March 4, 2022

**Re: Preserve at Woodmont – 7910 Paseo Del Norte NW
Erosion and Sediment Control Plan
Engineer's Stamp Date (3/1/2022) (C09E015)**

James D. Hughes, P.E.
Principal Engineer, Planning Dept.
Development and Review Services

## TEMPORARY SEDIMENT AND EROSION CONTROL DRAWINGS

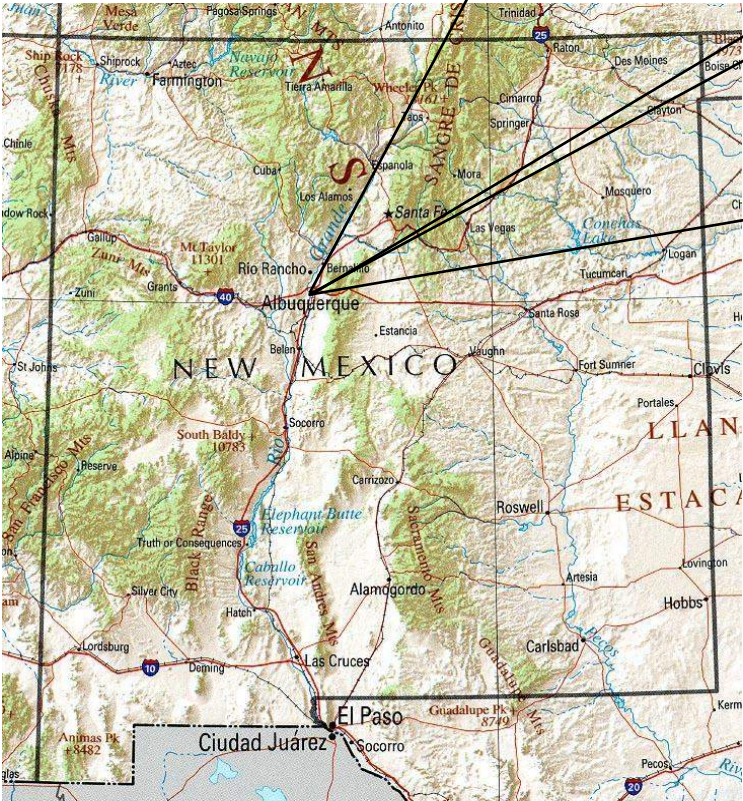
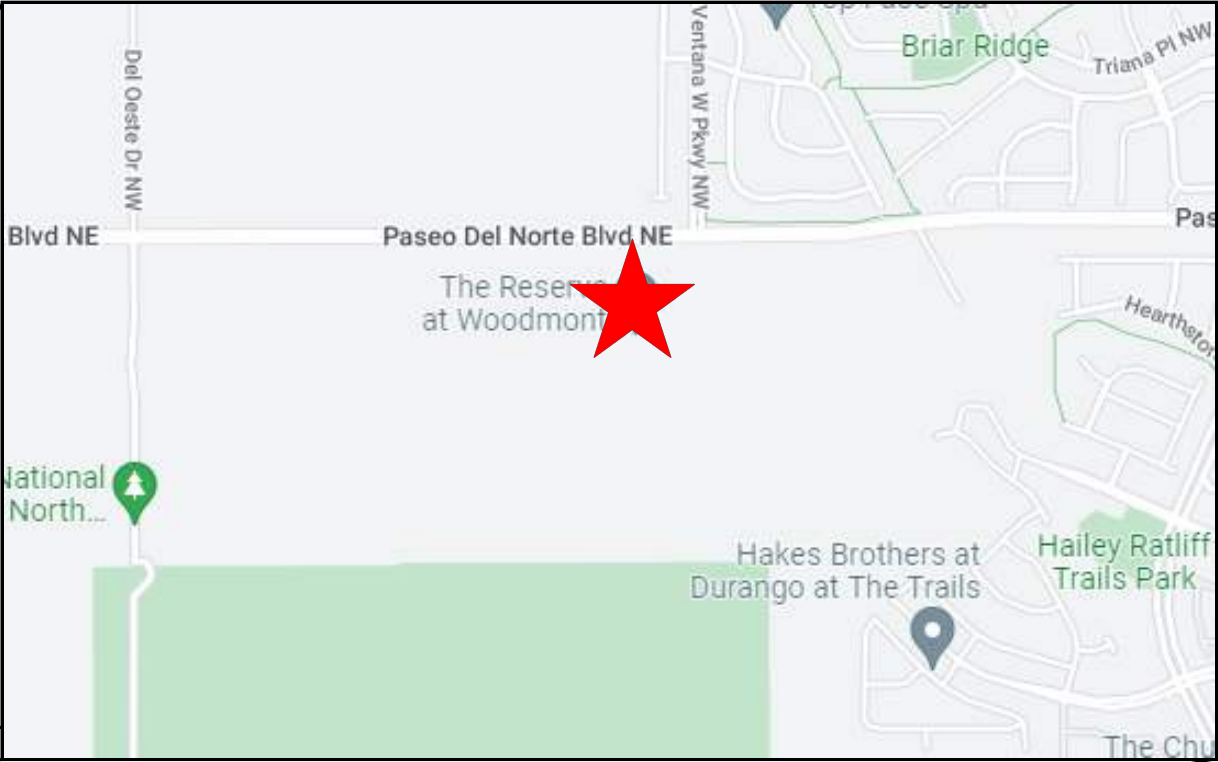
1. The limits of disturbance must be shown accurately (missing).
2. The SWPPP must include site-specific interim and permanent stabilization per CGP 9.4.1.c.i. The Landscape Plan and Work Order sheets can be used to satisfy this requirement and should be submitted separate from the ESC Plan with the application to the Stormwater Quality Section of the Planning Department and they should be included in the SWPPP. Provide a specification on the ESC Plan for any disturbed areas not covered by the Landscape Plan or Work Order sheets.

3. List operators on the plan, including name, phone #, and e-mail address.
4. Identify stormwater team members:
 - a. Personnel who are responsible for the design, installation, maintenance, and/or repair of stormwater controls (including pollution prevention controls);

6. Soil information – add a table with name type, particle sizes, and Erodibility factor (CGP 2.1.1).
7. The ESC Plan can't be approved for Grading or Work Order until the property owner's NOI has been reviewed and approved by City Stormwater Quality.

8. Vicinity map – add a zone atlas map clearly indicating location and street names.
9. City Standard ESC Notes are required on the ESC plan (attached).
10. Update the engineer's stamp date each time the plan is changed.
